**Howerton Services, PLLC**  
**License # P-1716**  
3513 Cathedral Bell Road  
Raleigh, NC 27614  
(919) 270-3460

Subject: 32 Dauphine Street  
Fuquay Varina, NC 27526  
Foundation Wall Expanded Footing Letter  
Harnett County Permit #: SFD2308-0046

Crawl Space Foundation Plan

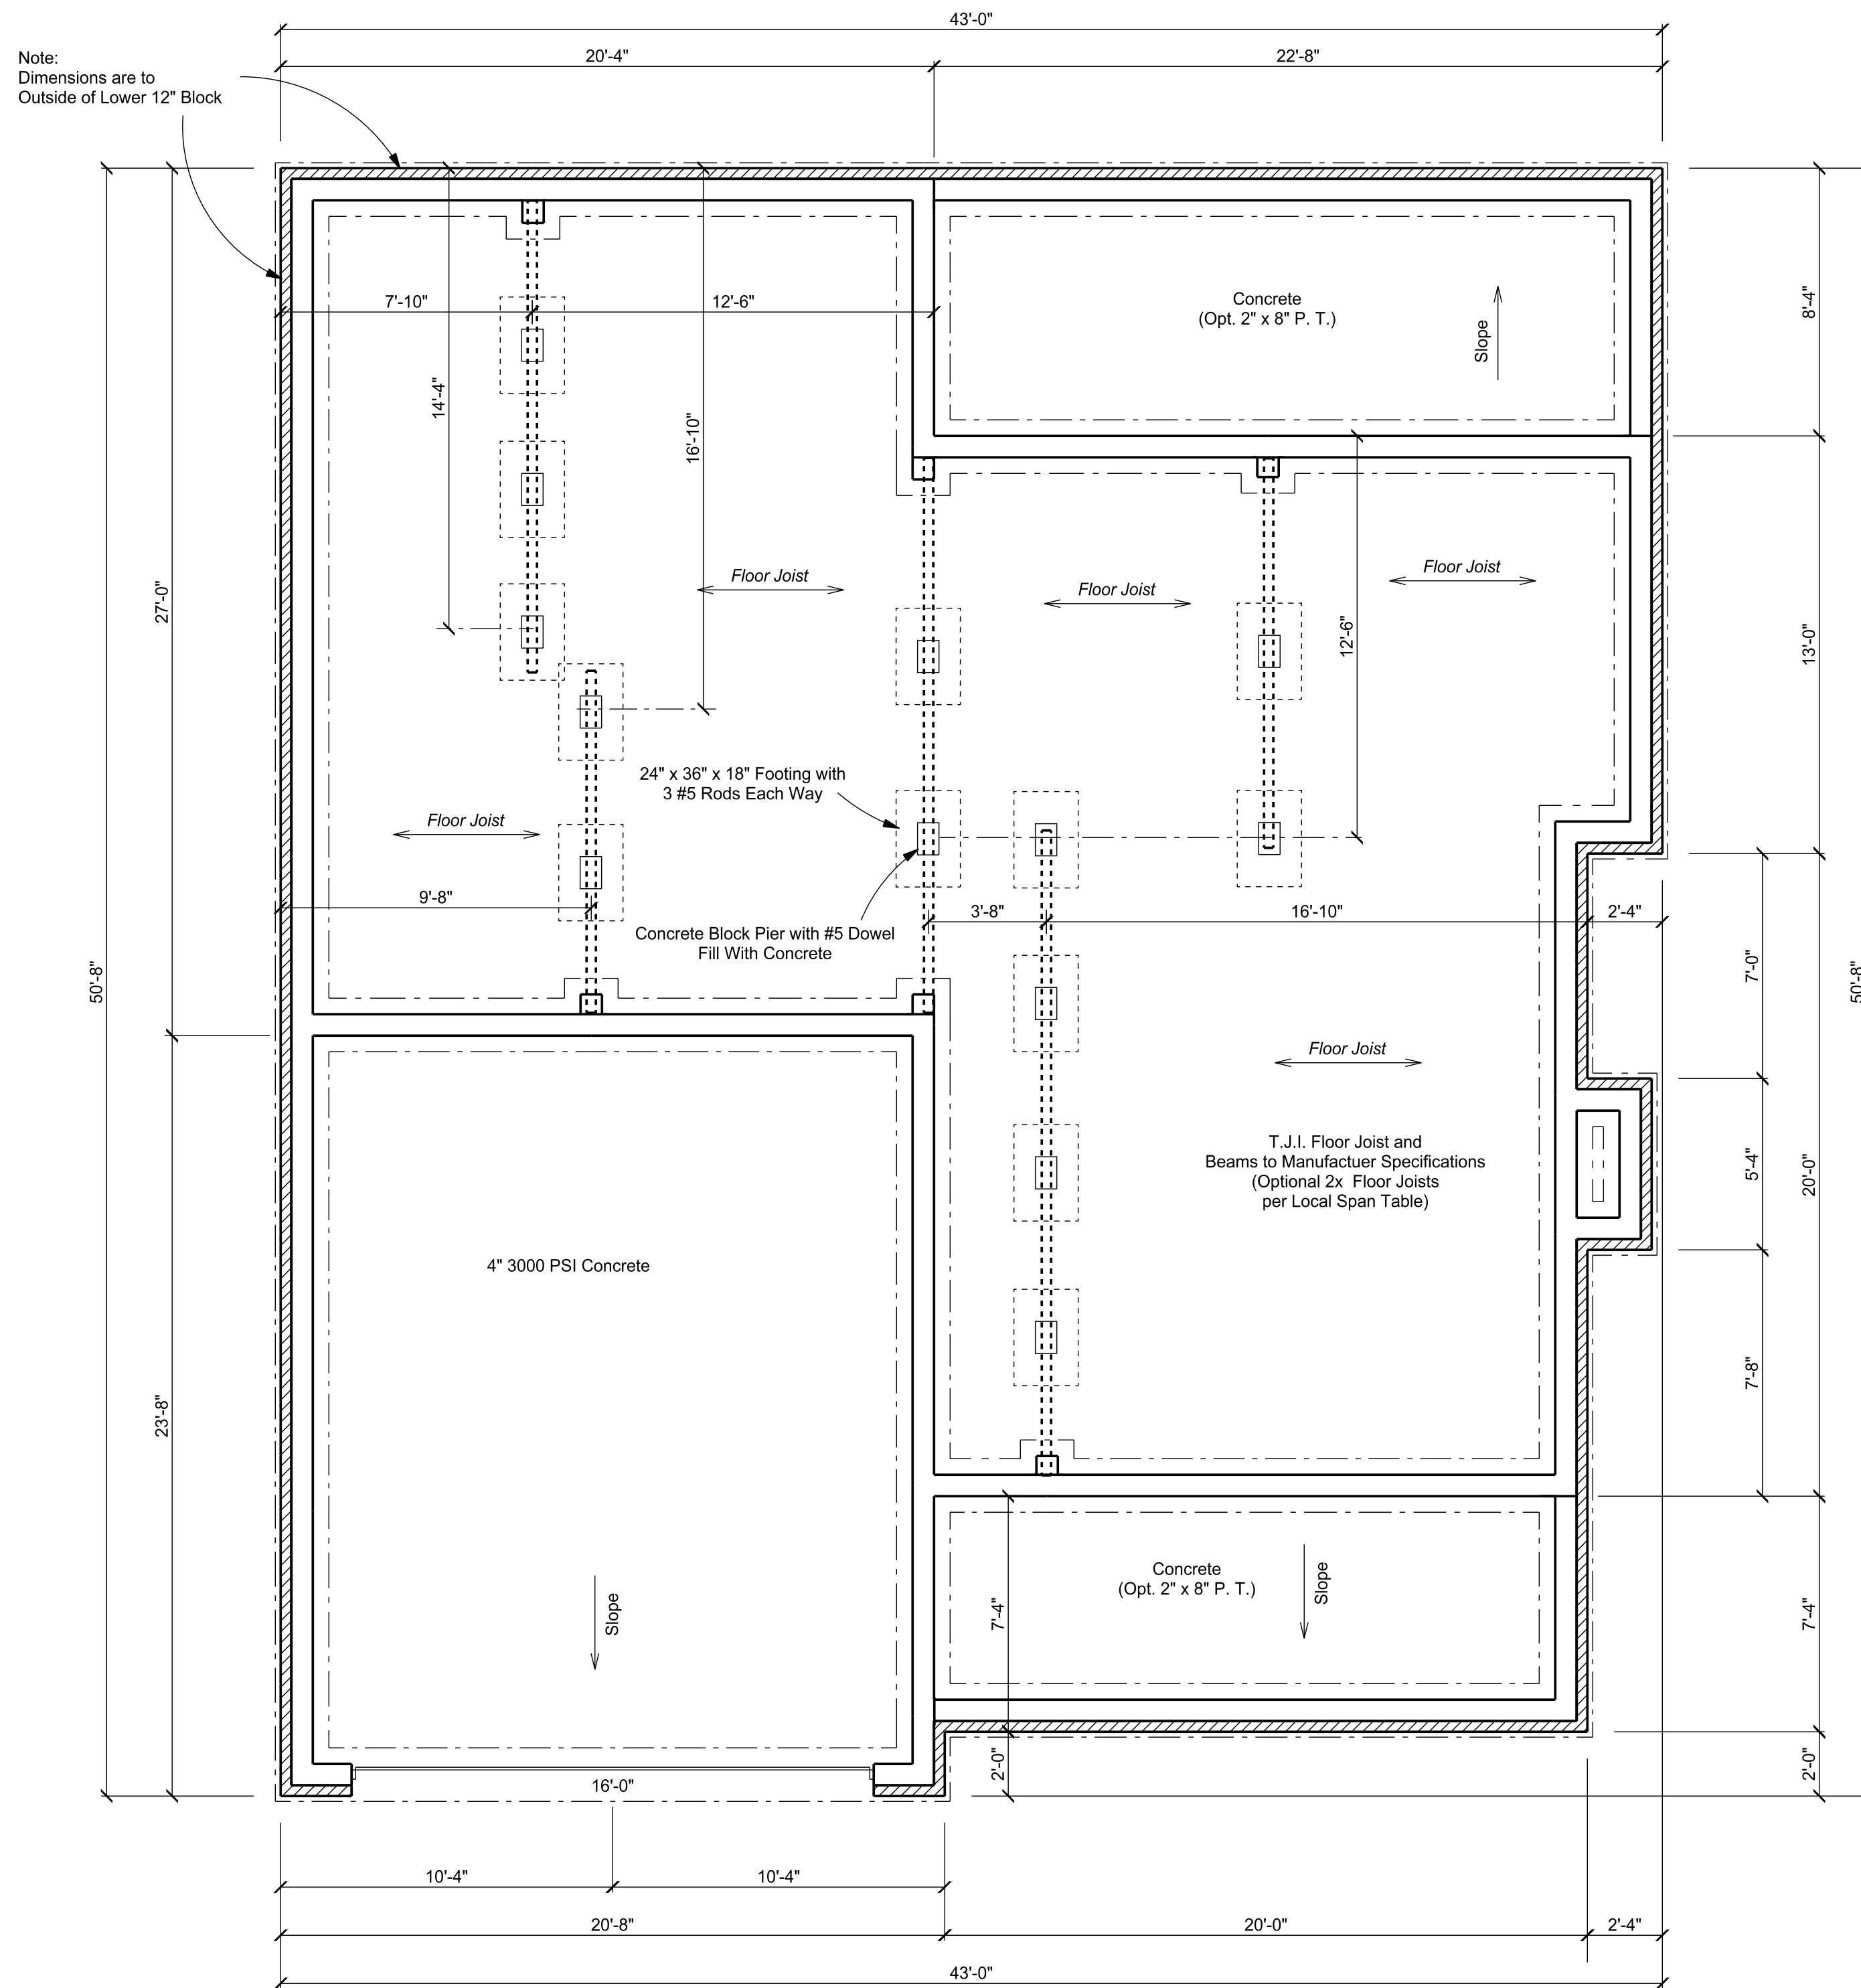
- The footings for the left side Garage foundation wall were not excavated in the correct location. The interior edge of the left side Garage foundation wall is too close to the edge of the footings and there is not proper footing projection for the foundation wall. The Contractor excavated an additional 12" on the interior side with the improper projection. The #4 dowel bars were added to the existing footings to tie the proposed footings to the existing footings. The new portion of the footings were excavated to the proper dimensions, and they have the proper density (2000 PSF). The Contractor has poured the concrete for the expanded footing. The expanded footings for the left side Garage foundation wall are acceptable.

The left side Garage foundation wall footings noted above meet all the requirements of the 2018 North Carolina Building Code for Residences.
